Date: 20 December 2017
Our ref: DAS/10802/232857
Your ref: Land S of Summer Lane, Pagham

Discretionary Advice Service (Charged Advice)

Development proposal and location: Housing development on land south of Summer Lane, Pagham, West Sussex

- The Brent Goose Mitigation Plan produced to support the planning application (Ref: P140/16/OUT) for housing development on land south of Summer Lane, Pagham

Fig 1 – Eco 1

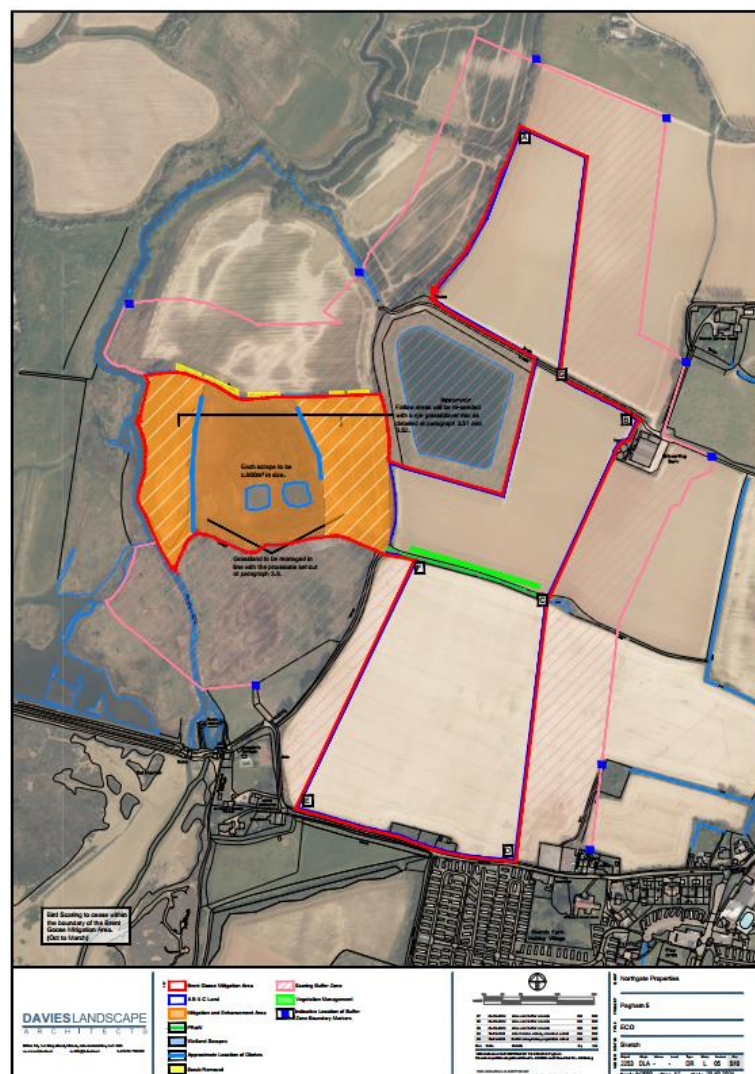
I can confirm that the location of the proposed mitigation land (shown at Plan ECO1) is acceptable as it is closer to Pagham Harbour than the application site. This means it will be favoured from an energetics point of view, as the geese will expend less energy flying to the mitigation land from their roost site than to the application site. In addition, the location adjacent to the SPA, but away from existing footpaths (and roads) is beneficial.

The cessation of bird scaring measures over the area described in Plan ECO1 is essential for the successful implementation of the measures described above, and would be an improvement over the current situation. Therefore, the commitment to cessation of bird scaring in perpetuity is welcomed.
